H21-0733-11

Application for a non-material amendment following a grant of planning permission.

SEE ATTACHED DRAWING 01582 D2308 SHOWING THE REVISED DESIGN & AREA NEEDED, WHICH IS A REDUCTION IN LAND AREA.

ALTERNATIVE CRANE HARDSTANDING ARRANGEMENT

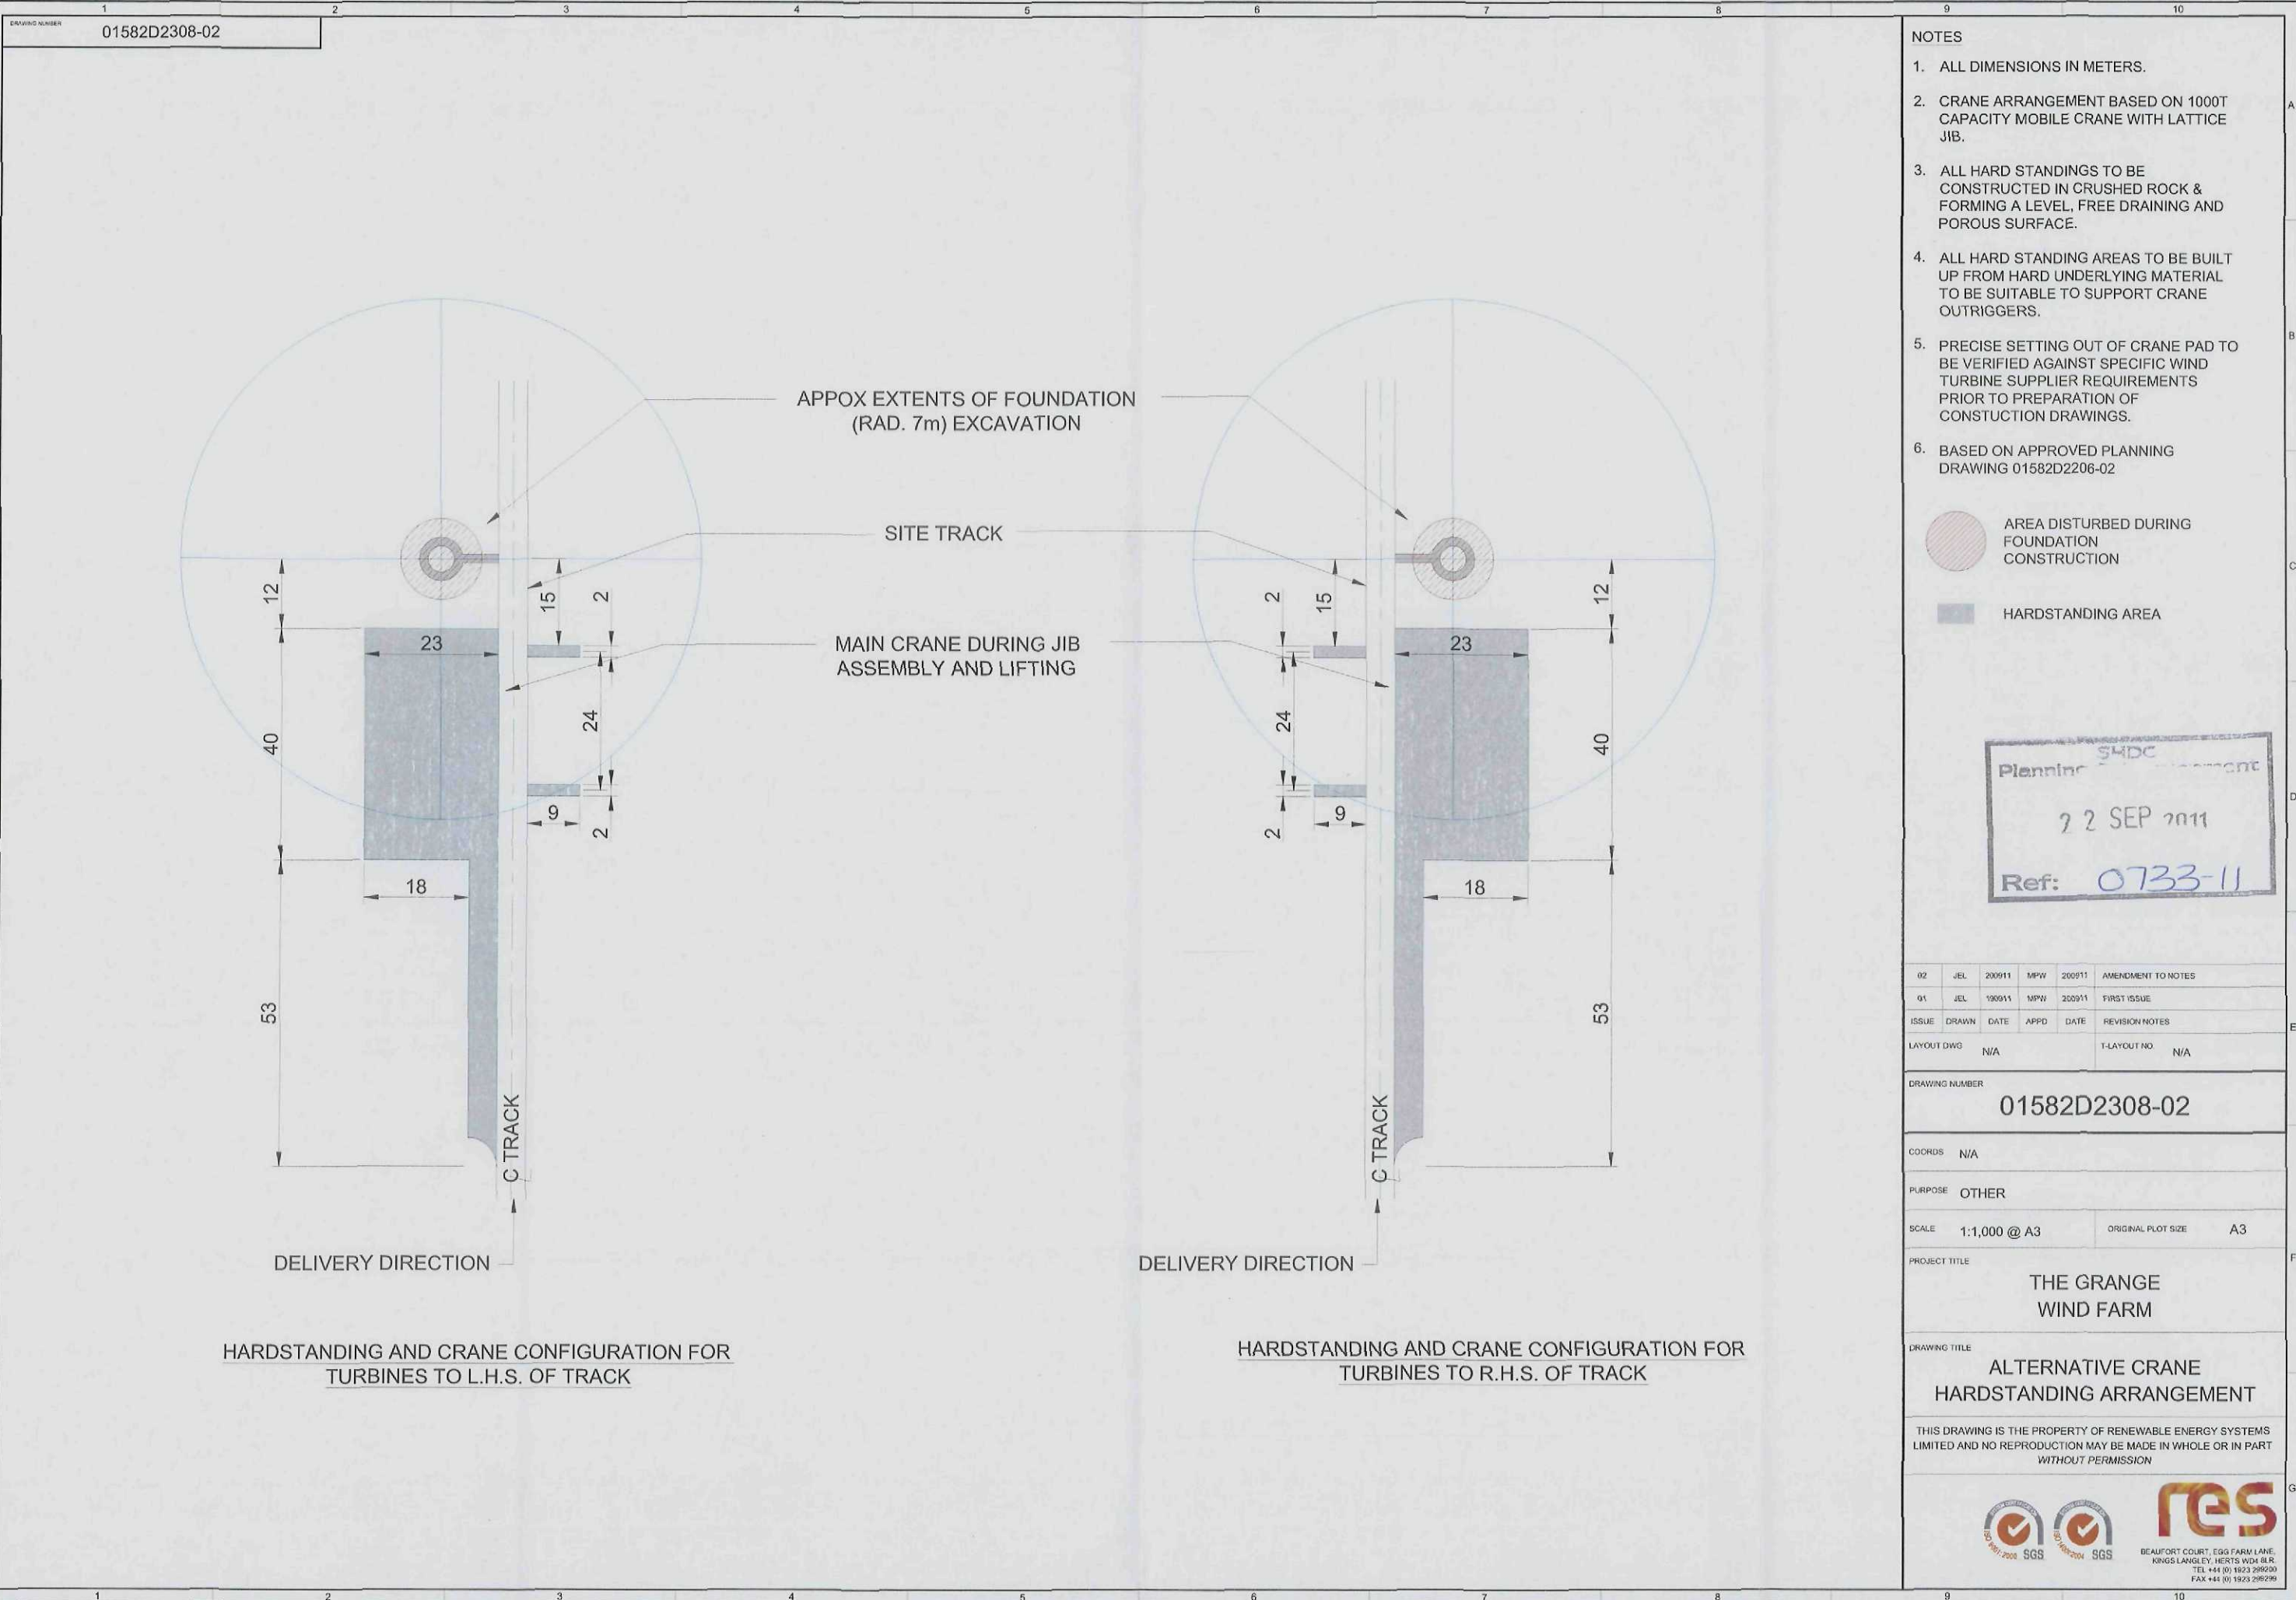
CHANGE IN TURBINE MANUFACTURERS LIFTING REQUIREMENTS FOR CRANES
